EPC STORMWATER REVIEW COMMENTS
IN ORANGE BOXES WITH BLACK TEXT

Final Drainage Report

I68 Training Facility

PCD File No. **PPR2440**

DRAINAGE REPORT

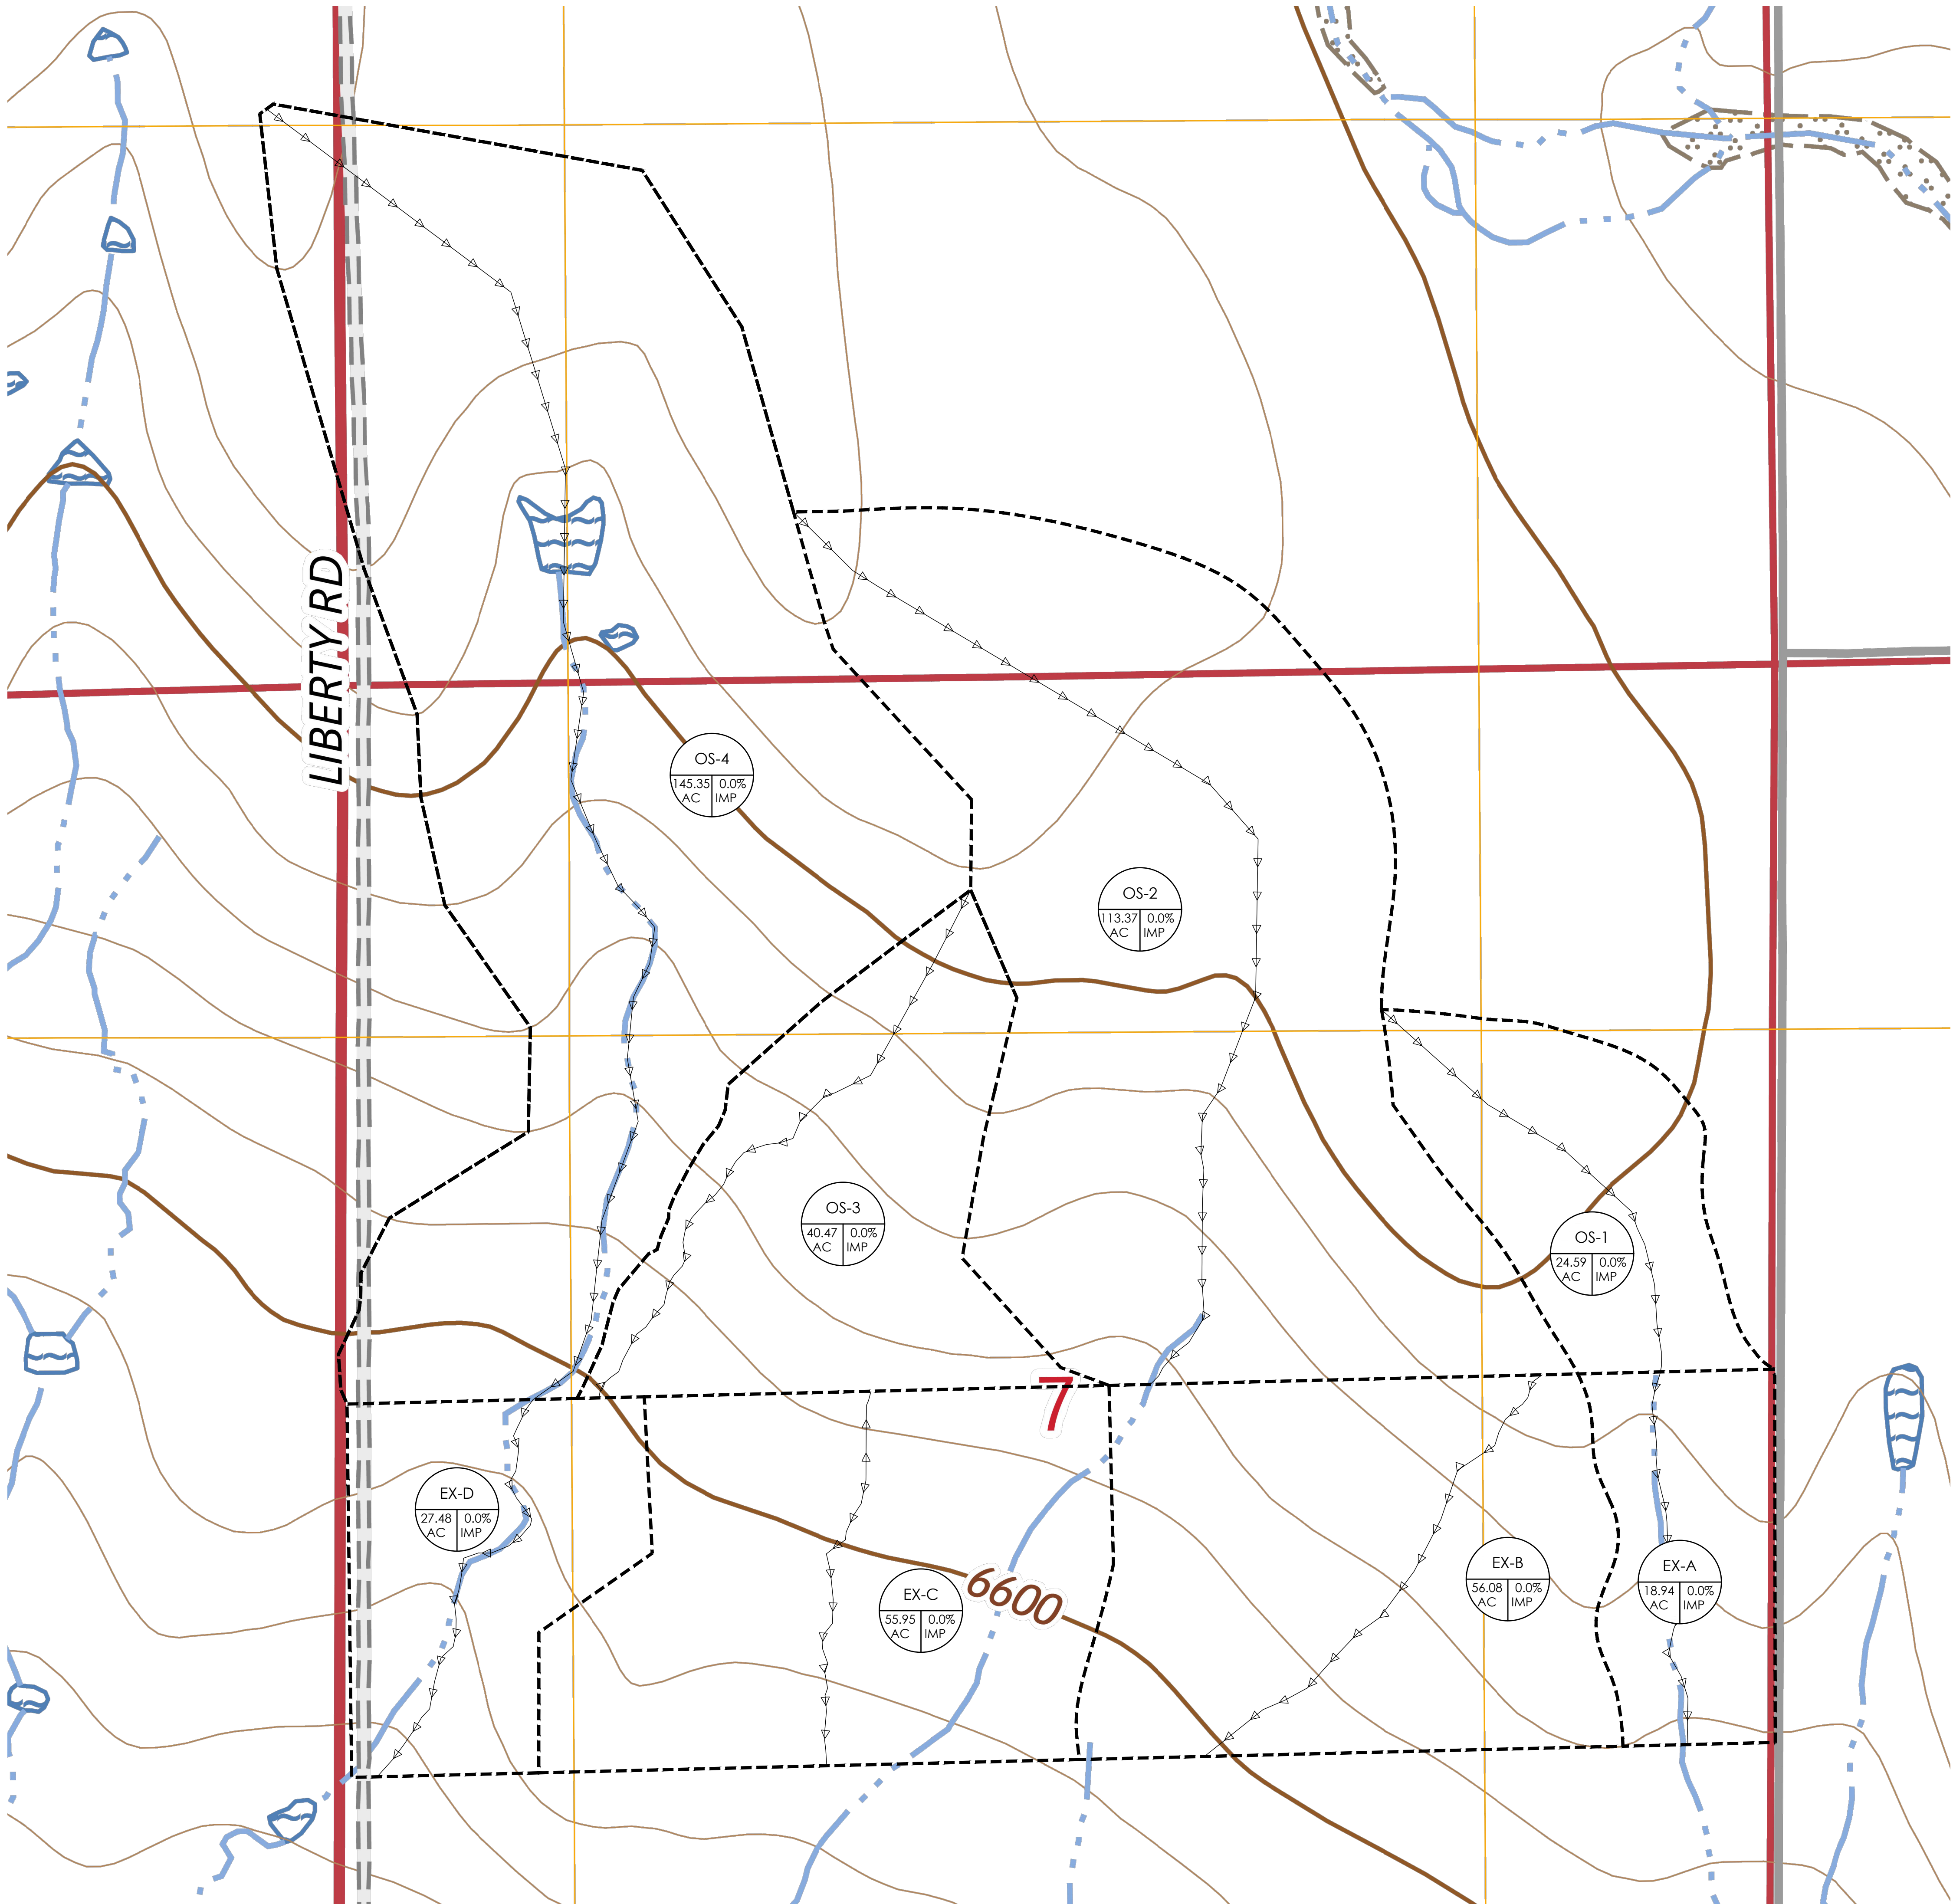
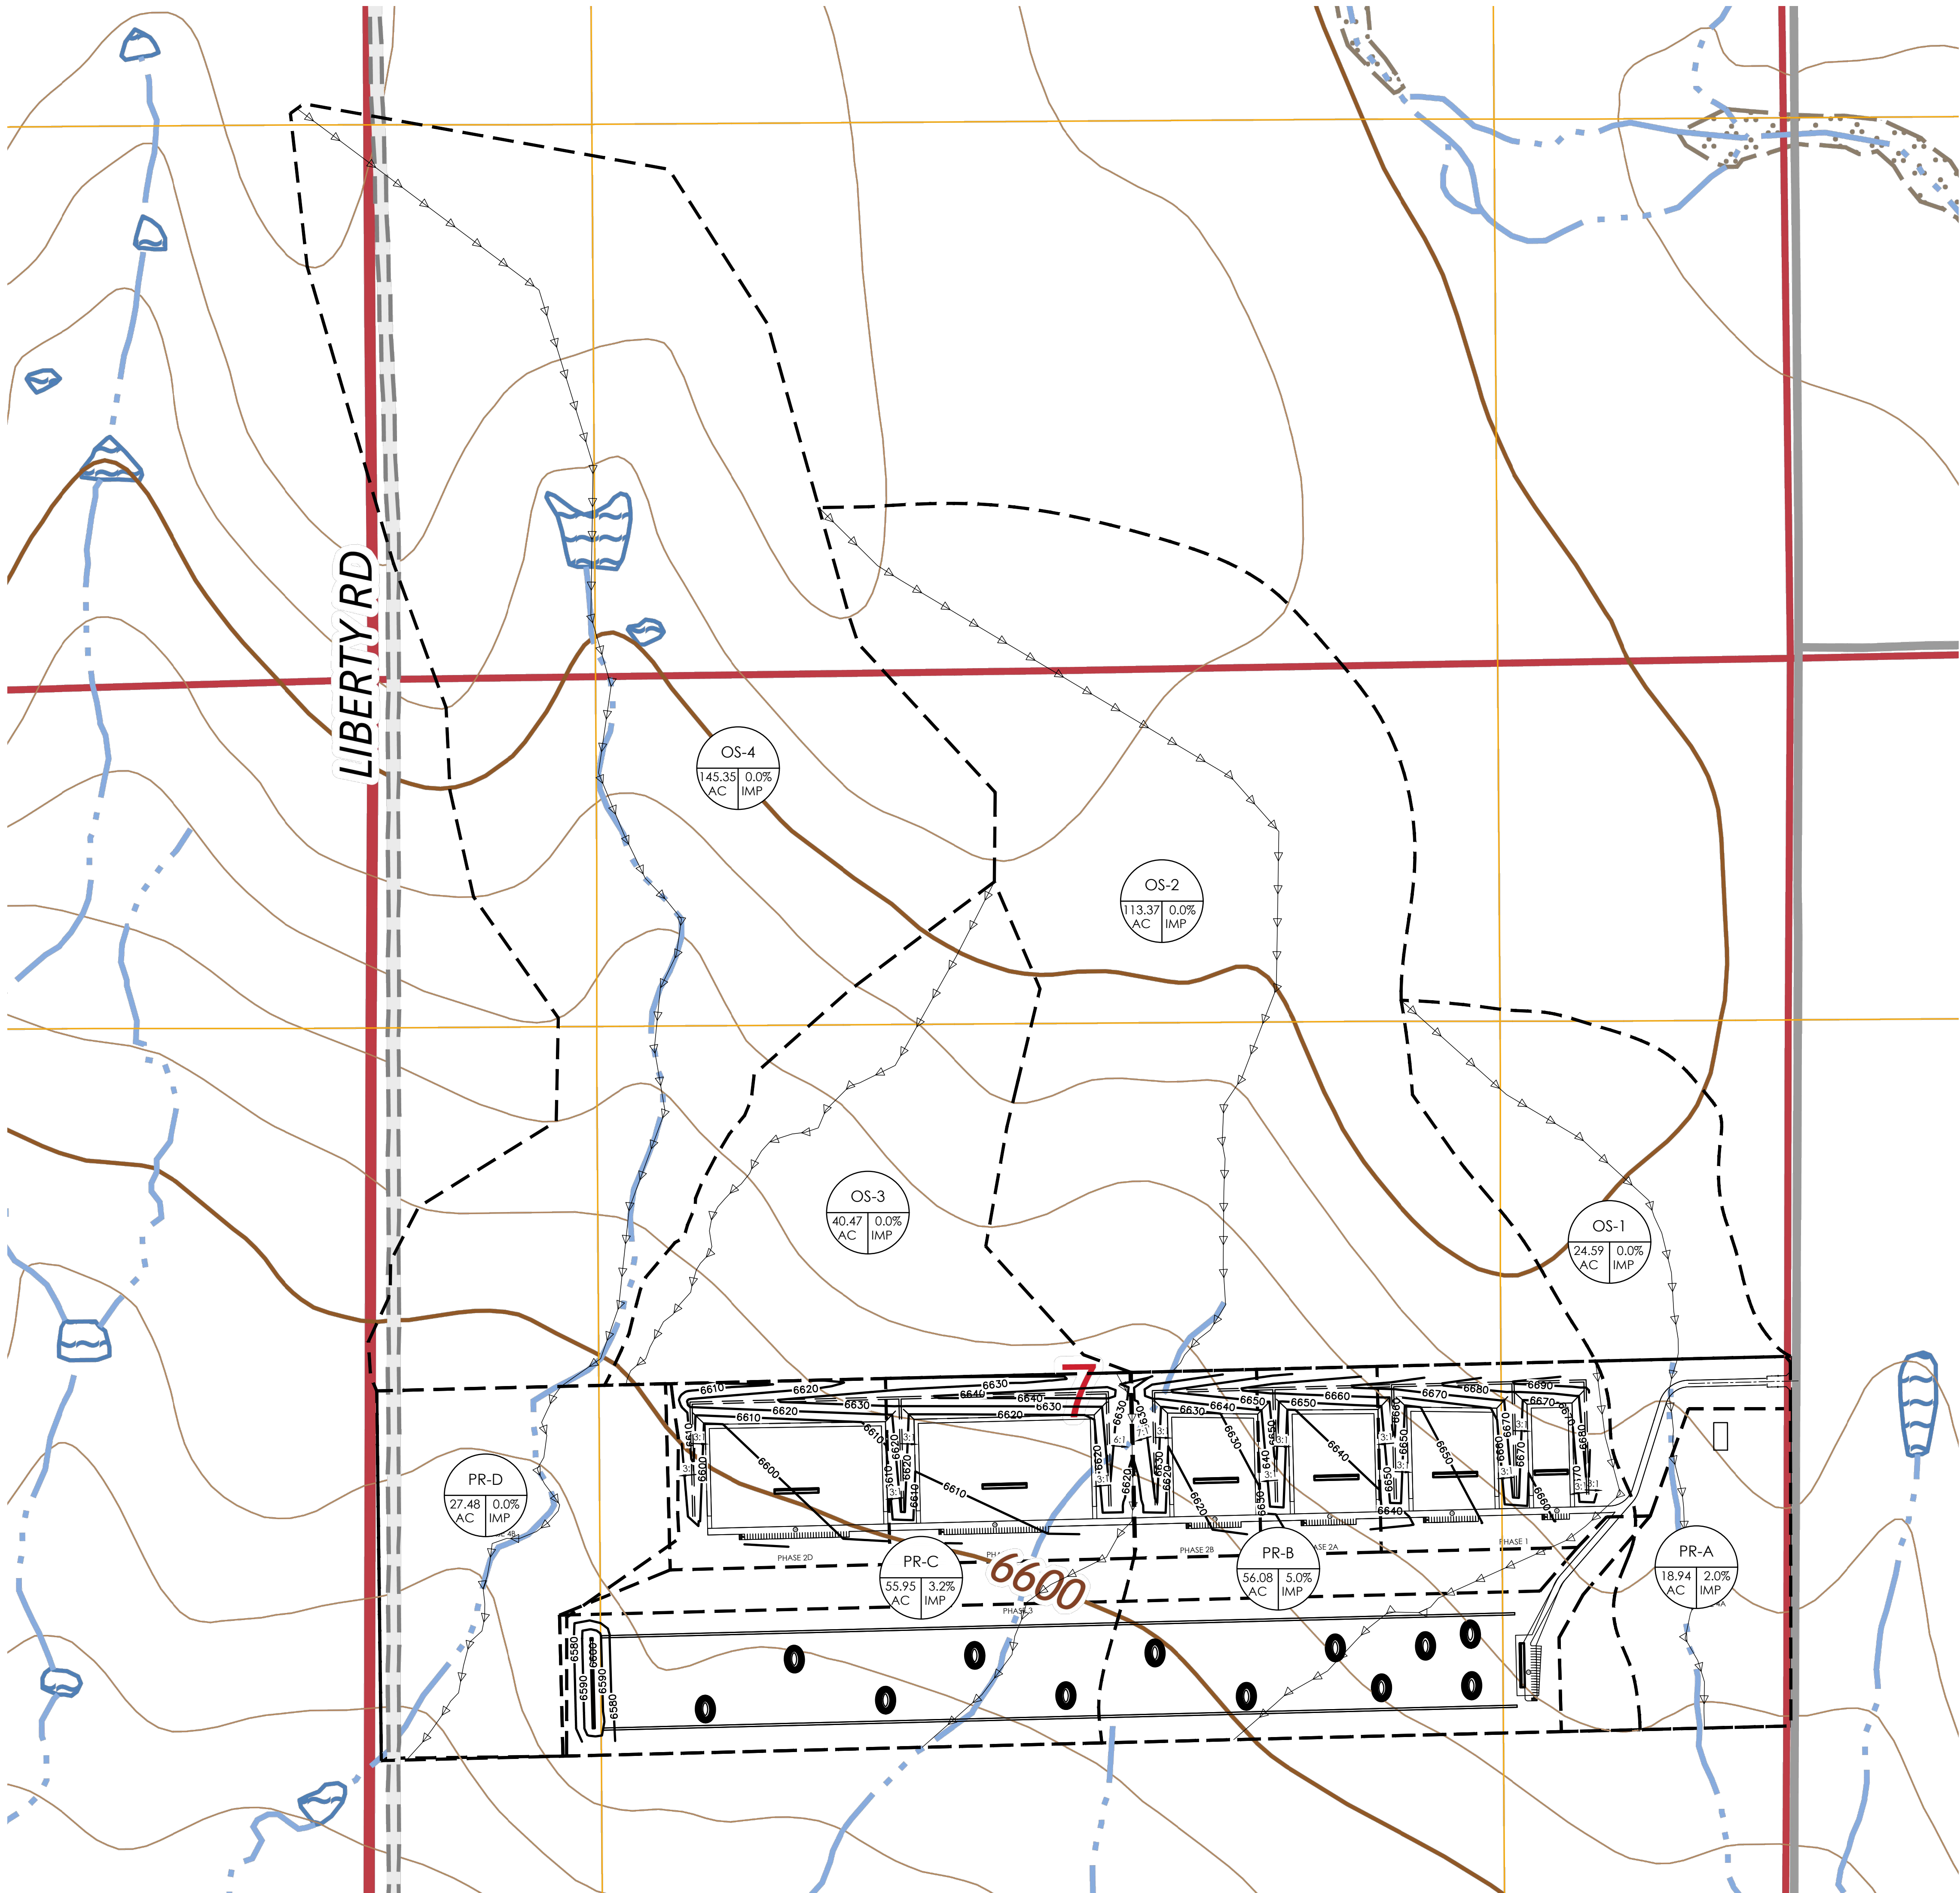
The proposed drainage map and calculations do not include all of the proposed buildings mentioned in the LOI (admin, lodging, support, gym) or the Connex City.

Please revise/clarify the sub-basin boundaries on the drainage map. There are 3 proposed basins yet it appears that there are multiple sub-basins shown.

Map shows PR-C.

Map shows PR-D

The contours and arials show concentrated flows leaving the site.

Please address erosion comments on the drainage maps
